RE: Sirrine Short Plat (SP-05-43)

The Kittitas County Community Development Services Department has determined that the Sirrine Short Plat is a complete application and hereby grants **conditional** preliminary approval subject to the following conditions:

TO: Graham Simon, Community Development Services Director  
FROM: Randy Carbary, Development Review, Planner II *RC*  
DATE: July 20, 2005  
SUBJECT: Sirrine Short Plat

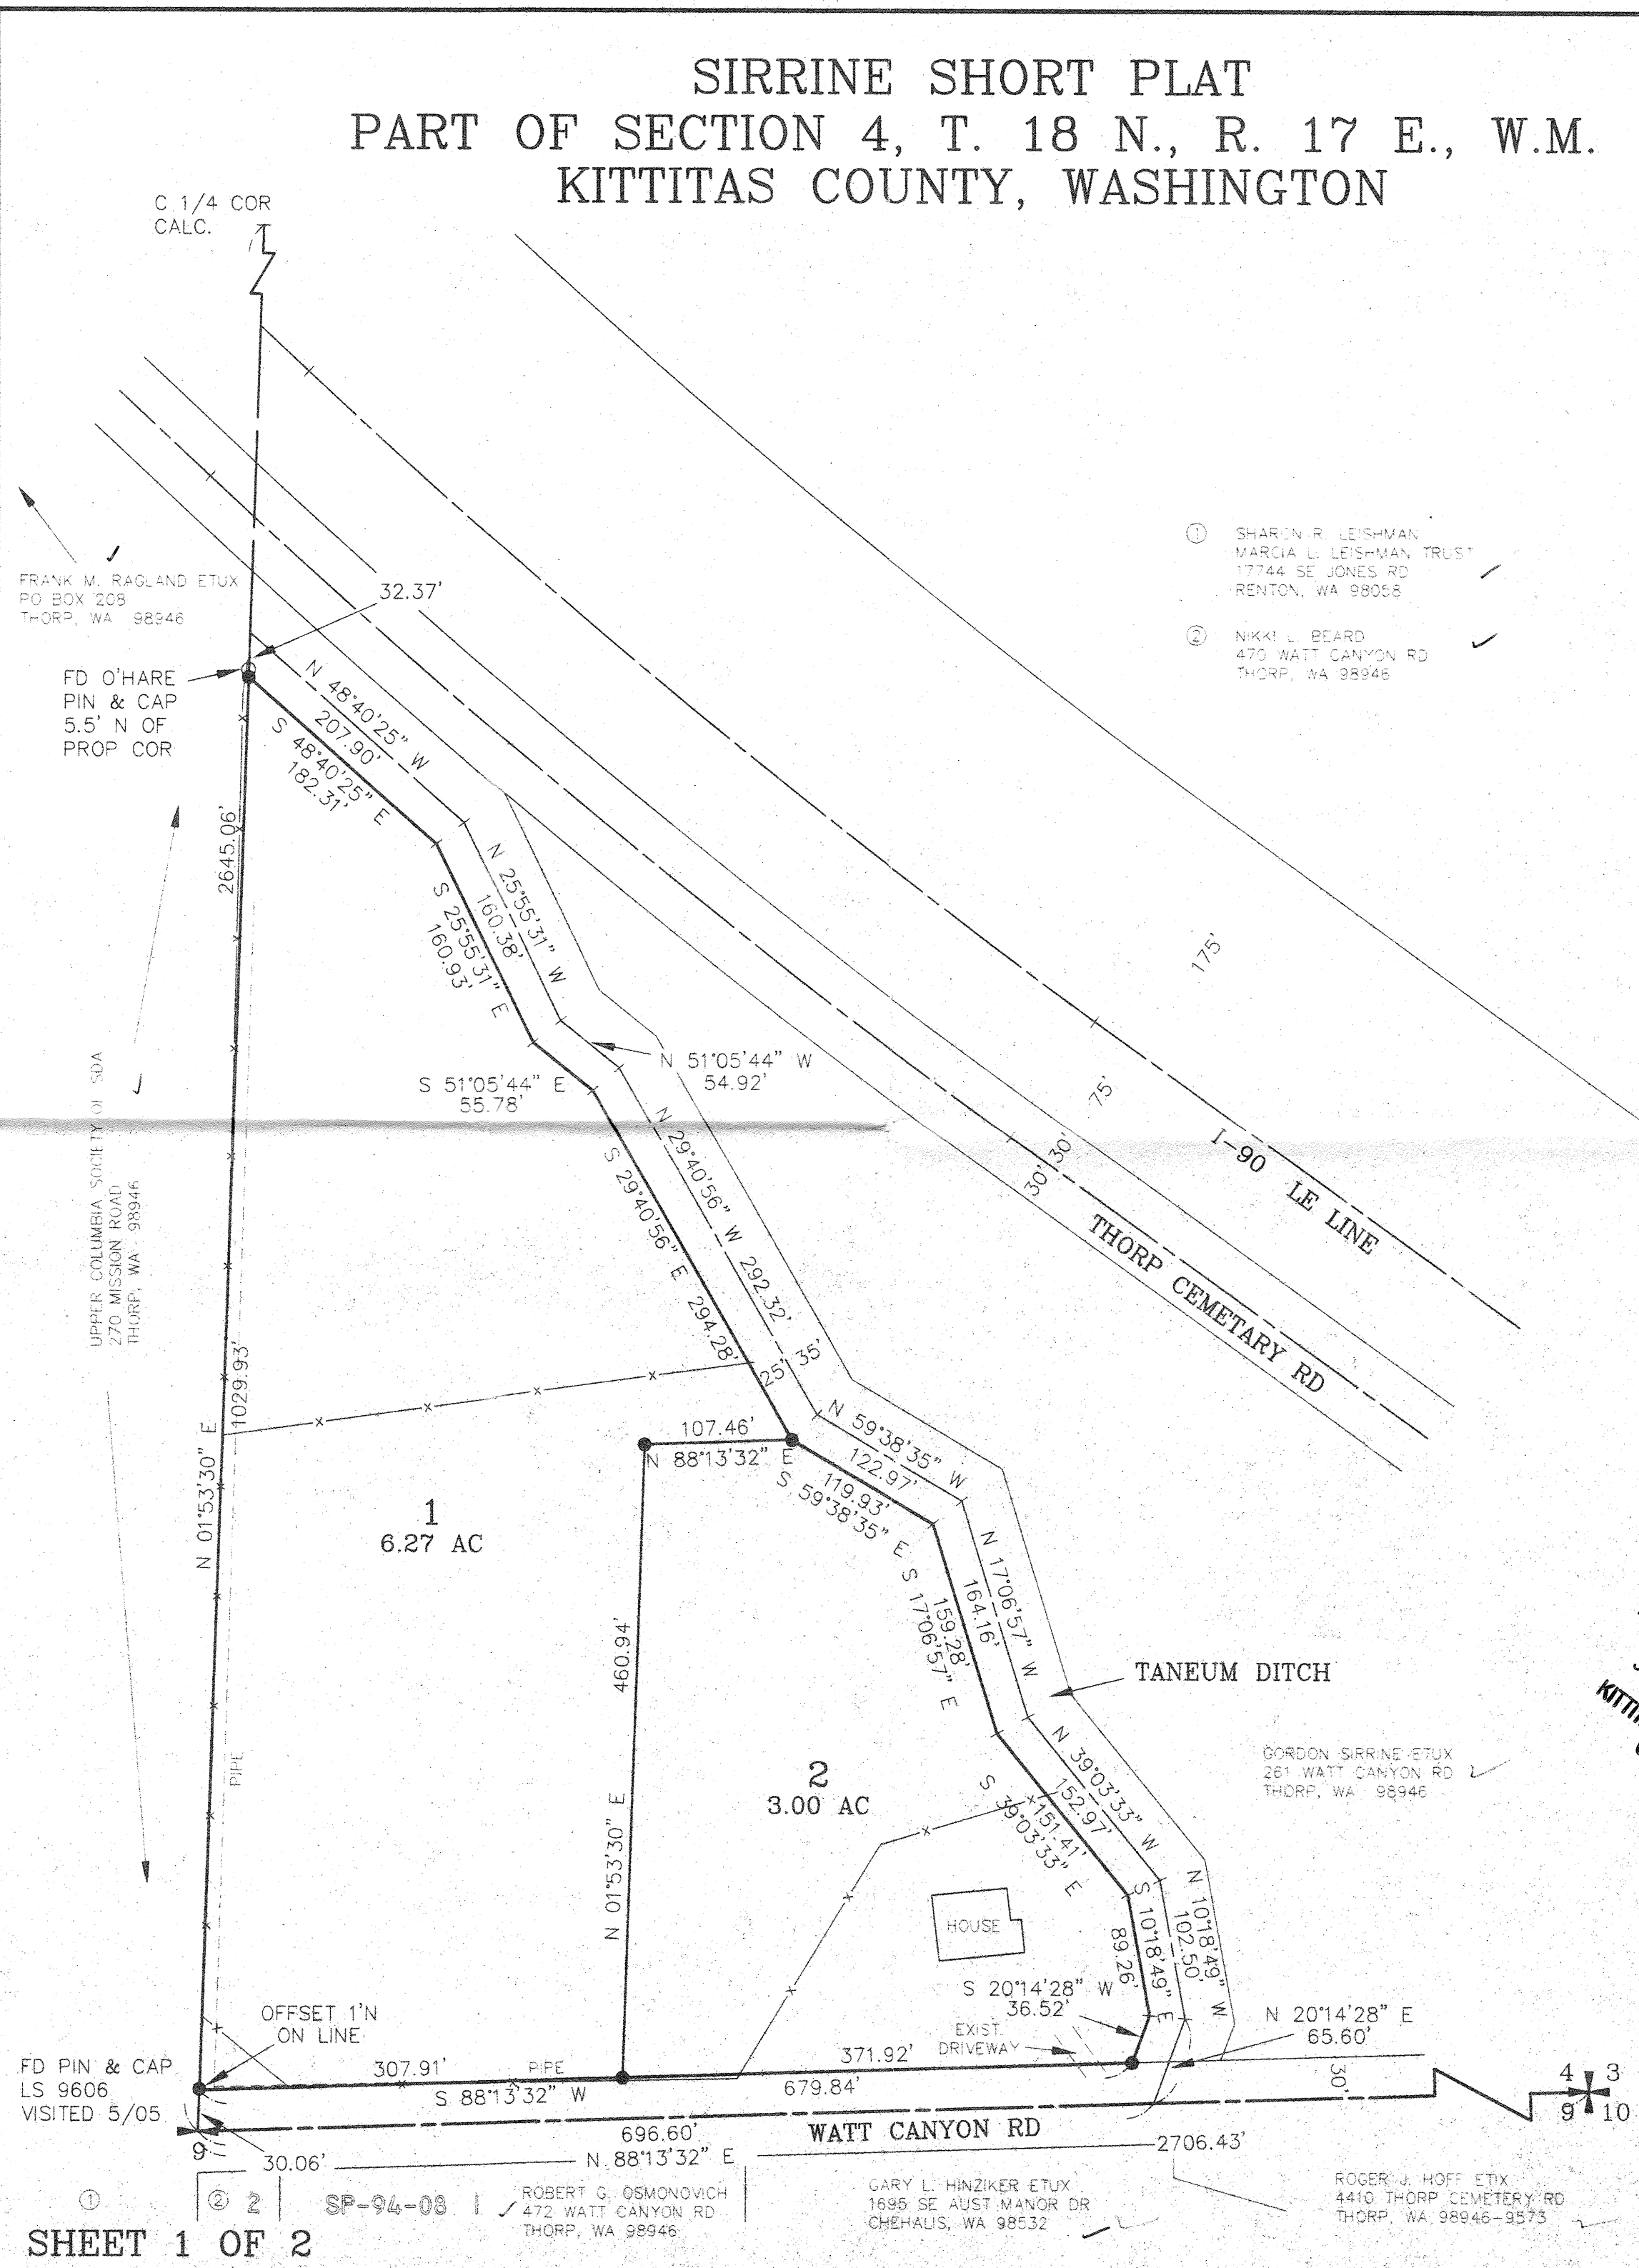
1. Both sheets shall reflect the short plat number SP-05-43.
2. **Attached you will find comments from the Kittitas County Department of Public Works and Kittitas County Environmental Health. Please see those documents for required plat notes and information on issues needing completion before final approval of this short plat.**

1. Driveway: The consolidation of access points and the creation of joint use driveways are preferred when practical. However, if the construction of a joint use driveway is not feasible, a separate driveway serving Lot 1 will be permitted.

2. Driveway – Joint Access: Access shall be constructed to serve no more than two parcels. (See current Kittitas County Road Standards)
  - a. Access Easements shall be improved to a minimum of 20'. The roadway width shall be 12', gravel surface.

- b. Maintenance of driveway approaches shall be the responsibility of the owner whose property they serve. The County will not maintain accesses.
  - c. Any further subdivision or lots to be served by proposed access may result in further access requirements. See Kittitas County Road Standards.
